Ribble Valley Borough Council
Council Offices
Church Walk,
Clitheroe
Lancashire
BB7 2RA

Phone: 0300 123 6780
Email: Kathryn.Walsh@lancashire.gov.uk
Your ref: 3/2024/0913
Our ref: 3/2024/0913/HDC/KW
Date: 18 June 2026

Location: Land off Back Lane Chipping PR3 2QA
Proposal: Proposed change of use of land to tourism and erection of five camping pods.
Grid Ref: 361993 441328

Job No: 251001	Drawn By: J.L.
Date: Dec 2025	Checked By: J.L.
Scale: 1 / 500 @ A1	Drawing No: 251001 / 01

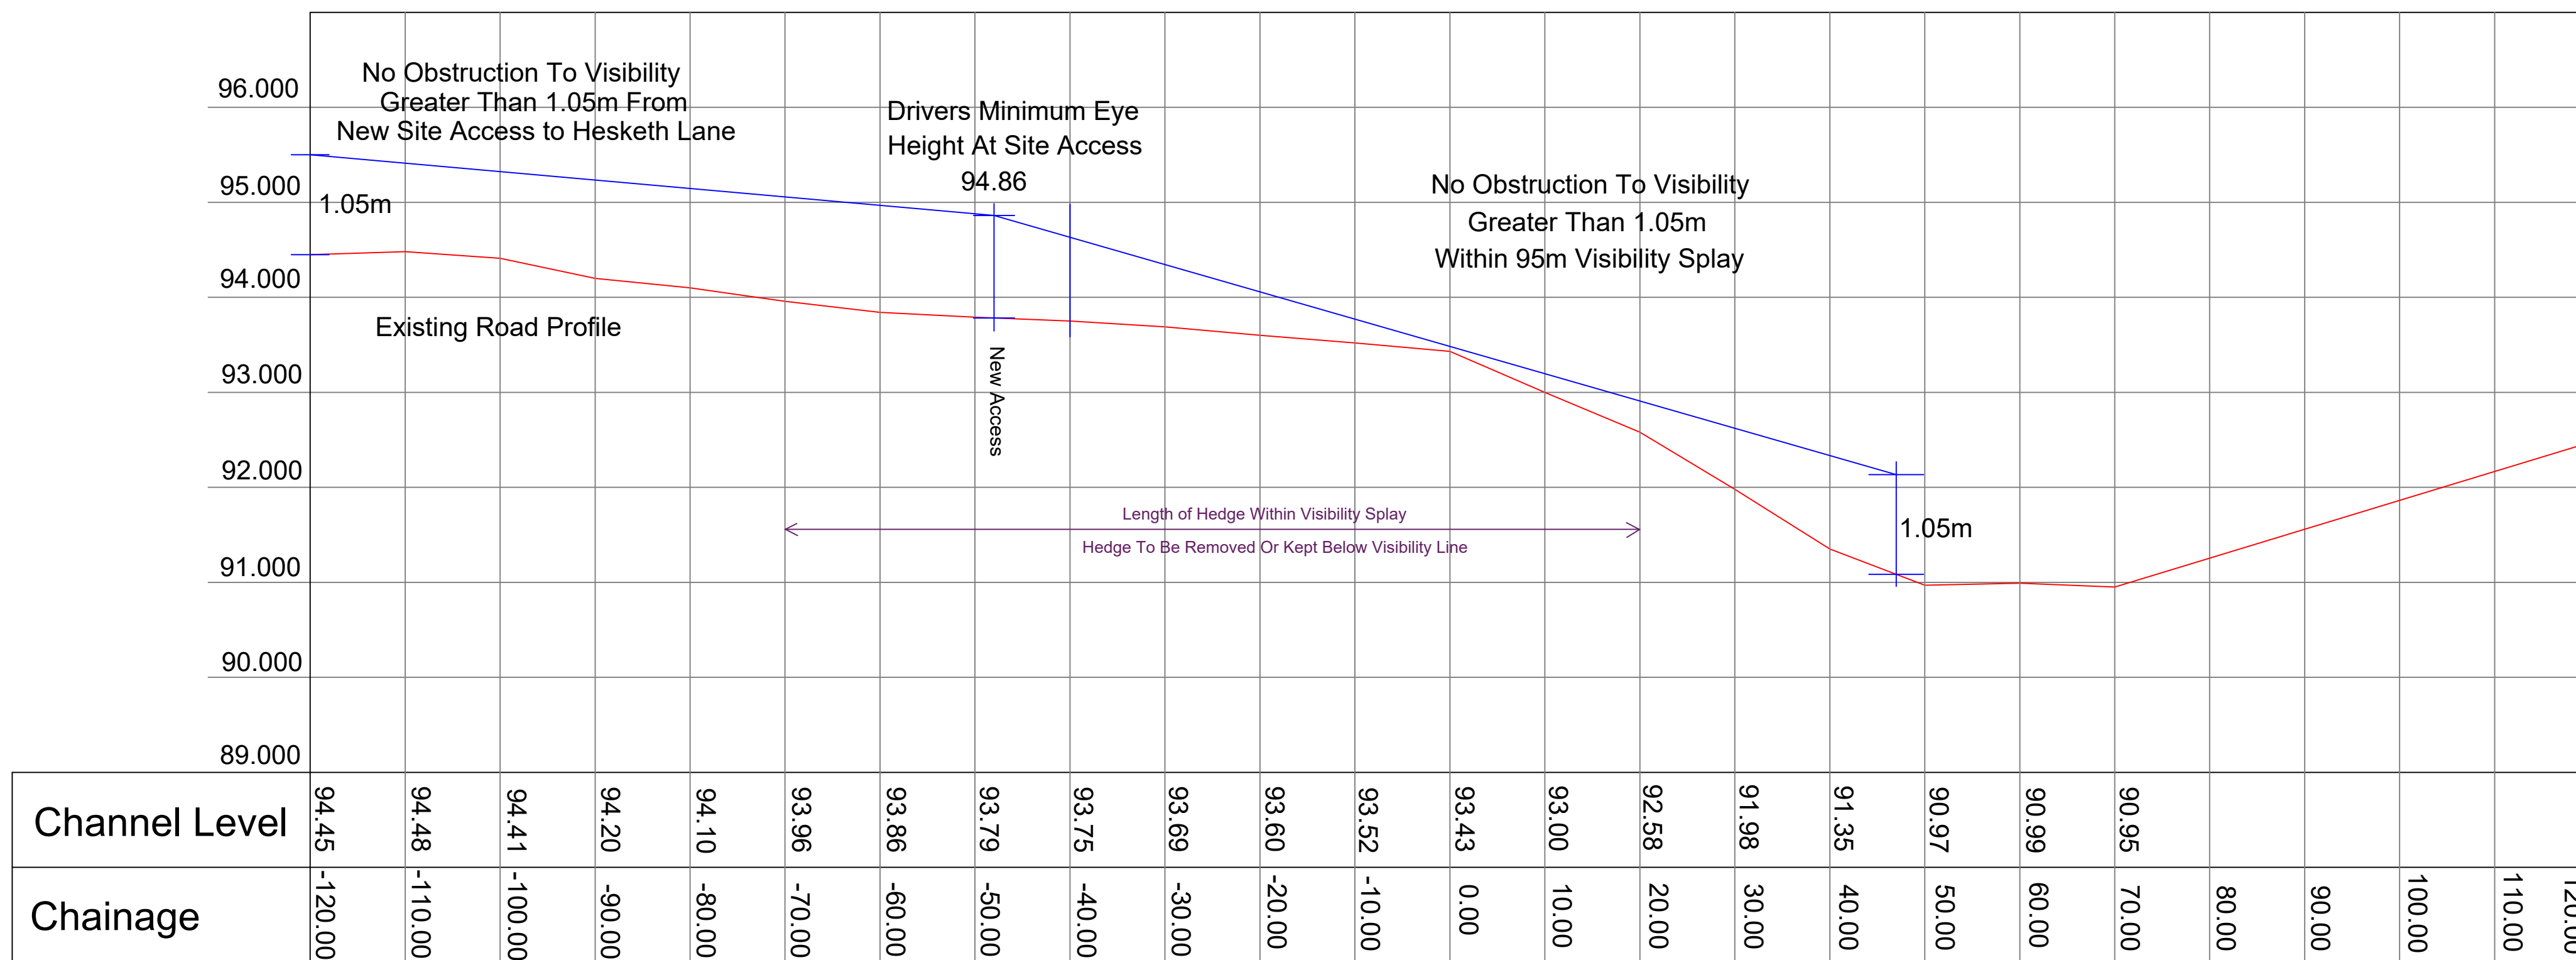
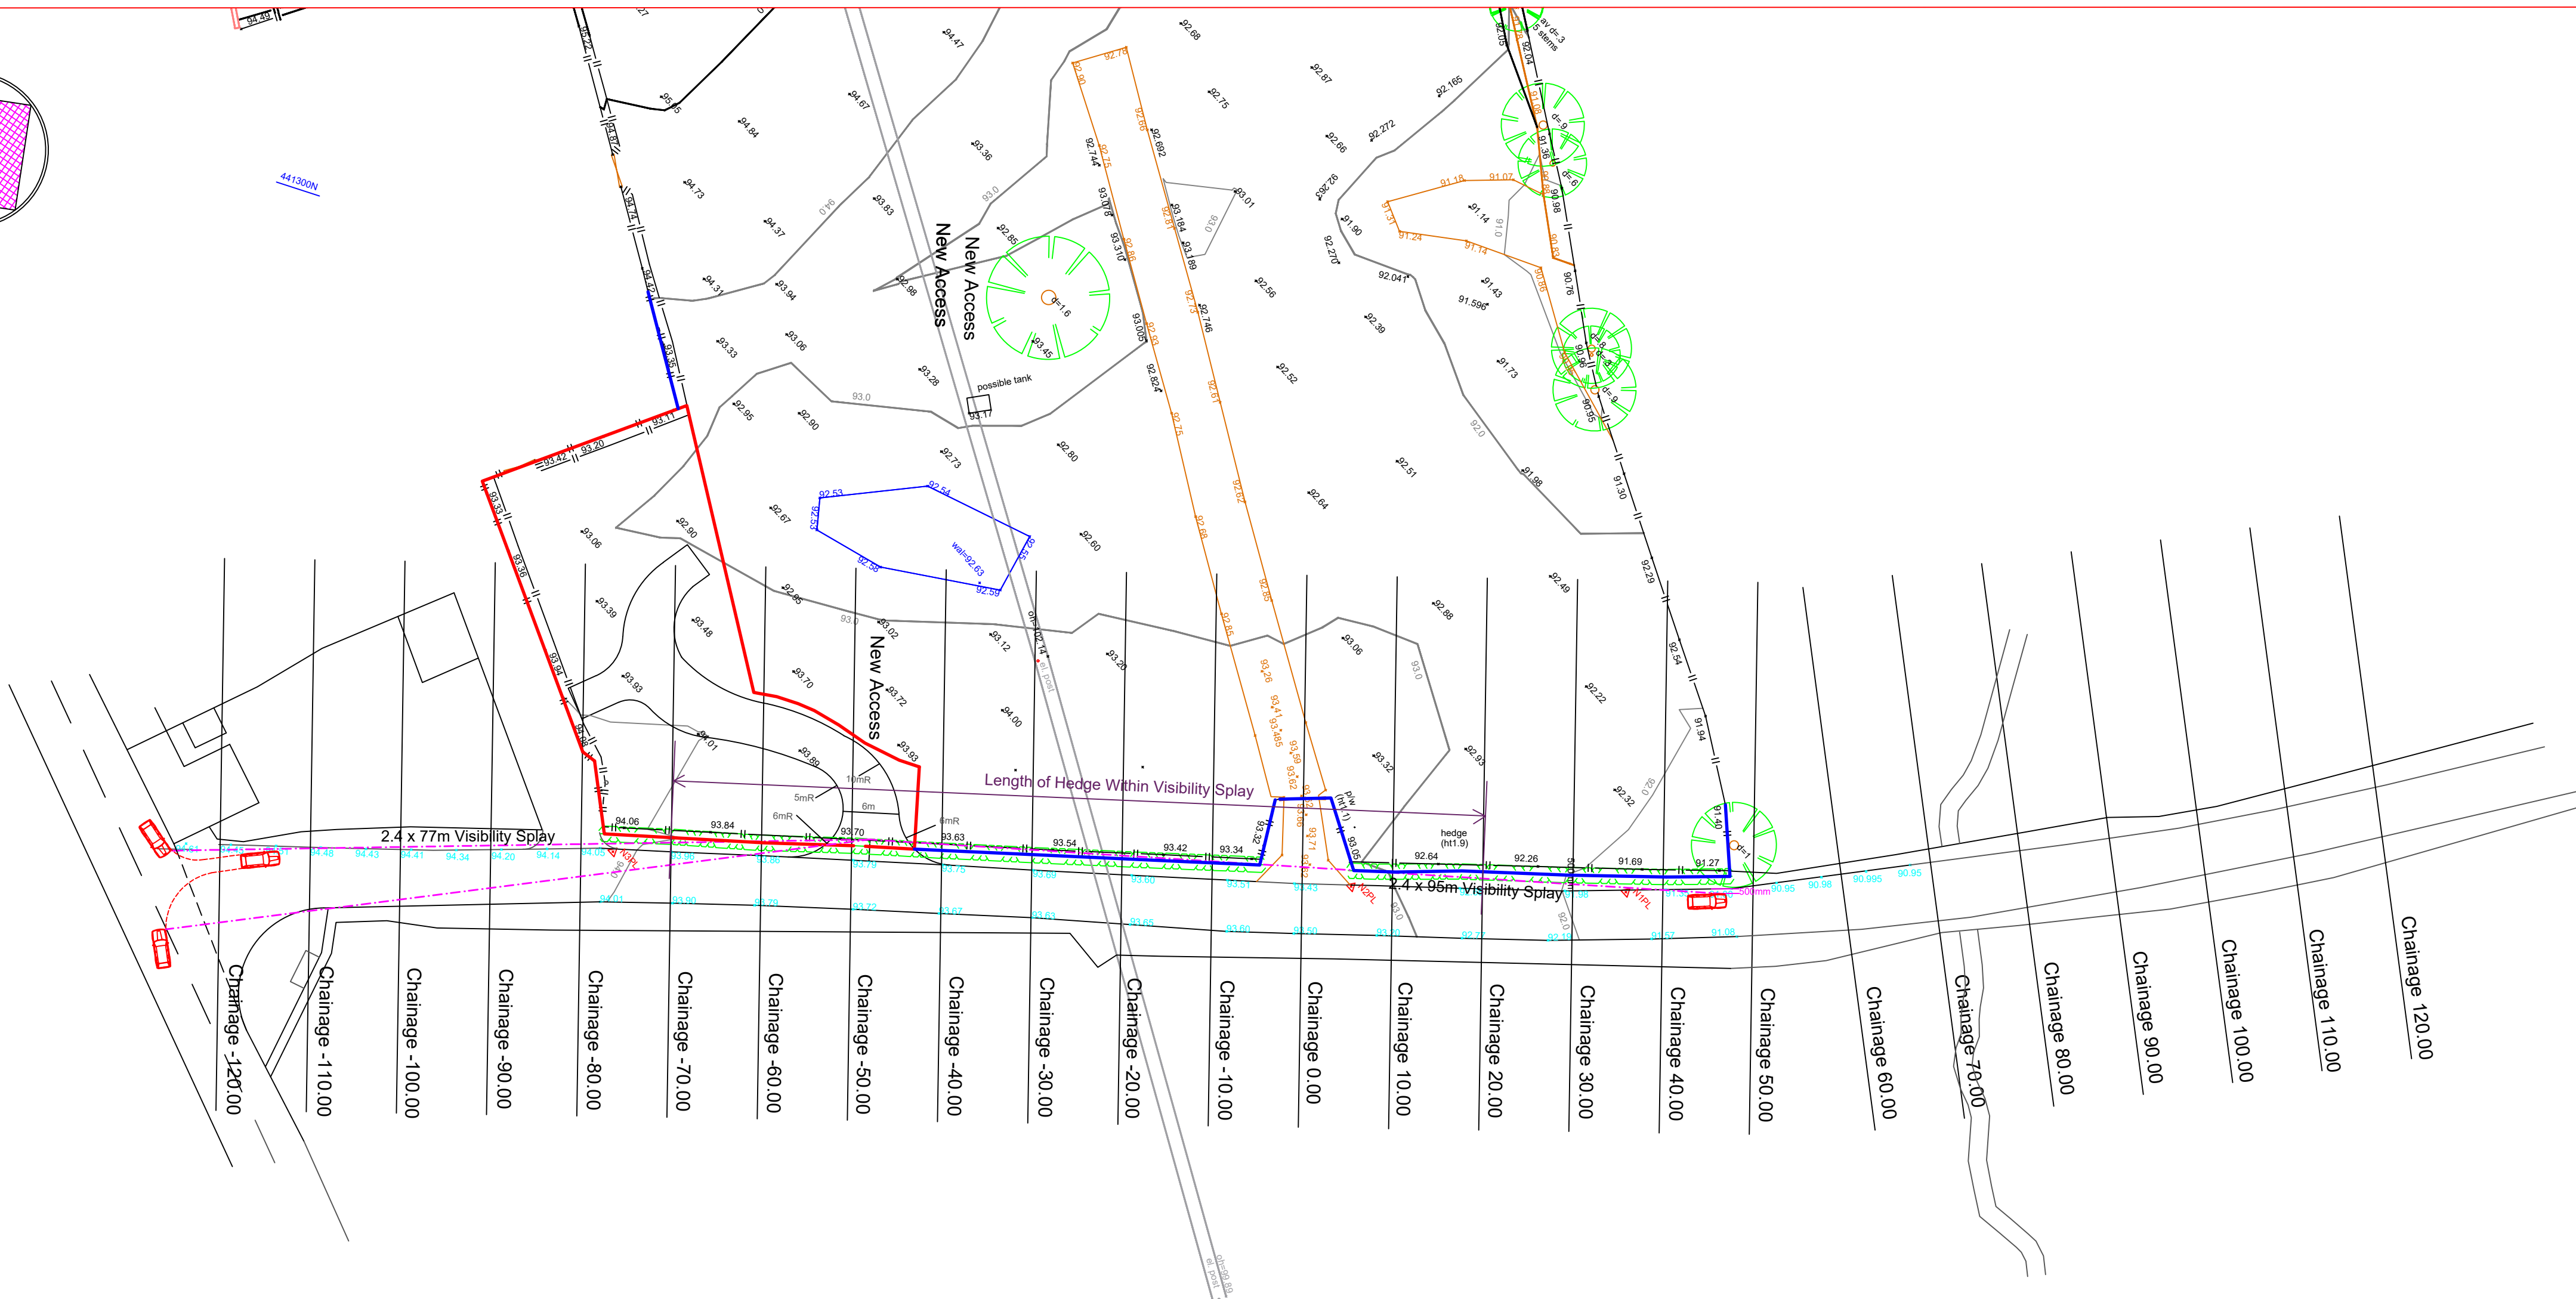
The applicant has also provided a traffic study, undertaken between Thursday 23rd January 2025 to Wednesday 29th January 2025, which details the 85th percentile of traffic speeds over 7 days to be 39.6MPH in the northeast-bound direction and 41.2 in the southwest-bound direction past the access. Visibility should be provided in line with the guidelines described in the DMRB CD109, Chapter 2, Design Speed. Back Lane also forms a gradient in both directions, which has been taken into account when calculating the visibility splays.

The preferred calculated visibility distances using DMRB are 102 m to the south and 95 m to the north. The applicant has provided a visibility splay within drawing number 251001 / 02. The drawing shows that the visibility to the north can be achieved and that the splay to the south provides clear visibility up to the junction with Hesketh Lane (77m) which is acceptable.

6. No use shall be commence until visibility splays 2.4 metres back from the centre line of the access and extending 77 m to the south and 95 m to the north along the nearside carriageway edge have been provided at the access, as shown on the approved plans, drawing number 251001 / 02. Nothing shall be erected, retained, planted and / or allowed to grow at or above a height of 0.9 metres above the nearside carriageway level which would obstruct the visibility splay. The visibility splays shall be maintained free of obstruction at all times thereafter for the lifetime of the development.
